Subject: **New DC** wef 30/11/2022 FW: SET UP APPLICATION: Planning Consent 2022/1539: Decision on Doors

Can you please set up a new DC application to discharge condition 3 from 2022/1539 wef 30.11.2022. (Note you do not need an application form to set this up) Please use the following details

From: Kieran Oliver [REDACTED]
Sent: 14 November 2022 13:47
To: Planning (SNC) <Planning.snc@southnorfolkandbroadland.gov.uk>
Subject: Planning Consent 2022/1539: Decision on Doors

SUPREME **1.8M** EXTERNAL BIFOLD DOORS

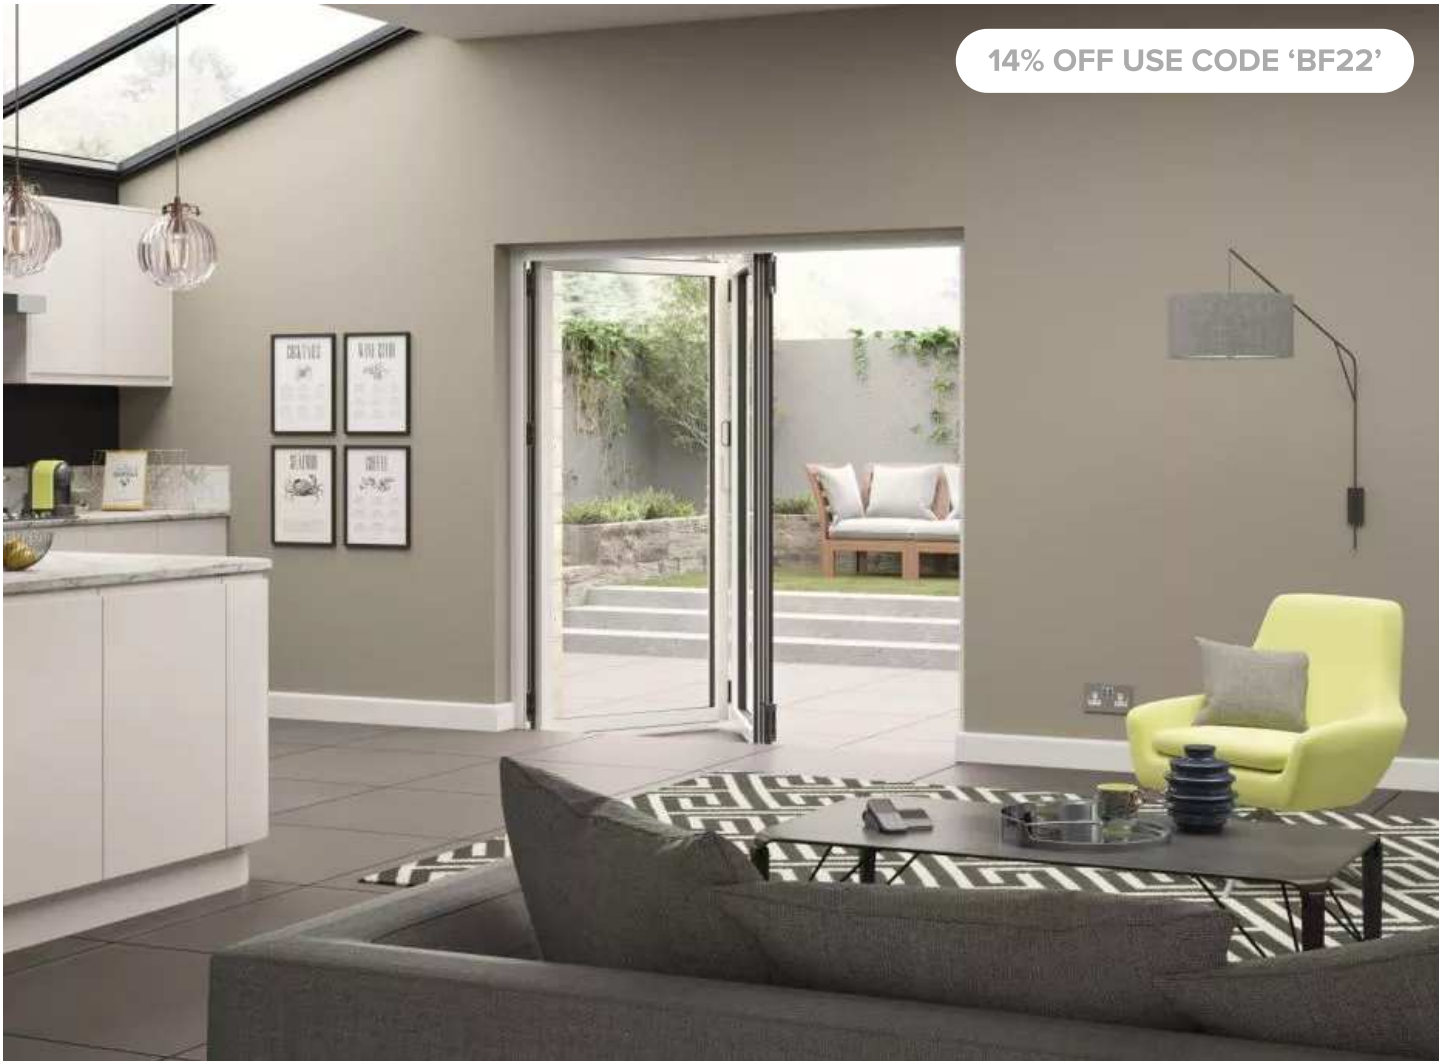
The submitted details are fine providing you can confirm that the doors have a non-plastic finish. If you can also confirm the number of the condition you are looking to discharge we can then set up the discharge of condition application. Do ring if you have any further queries.

Thank you for the door details. As the building is an historic listed building we would not accept UPVC units. The doors should therefore either be in metal (usually powder coated aluminium) or timber. Once you have submitted revised details we will then set up a discharge of condition application as all details have to be formally discharge with a decision notice. Do ring if you need to discuss.

Thank you.
I can confirm the finish is not plastic and is powder coated aluminium.
This is to discharge condition 3.

Please find attached the revised door specification for compliance and consideration to listed granted approval point 3:
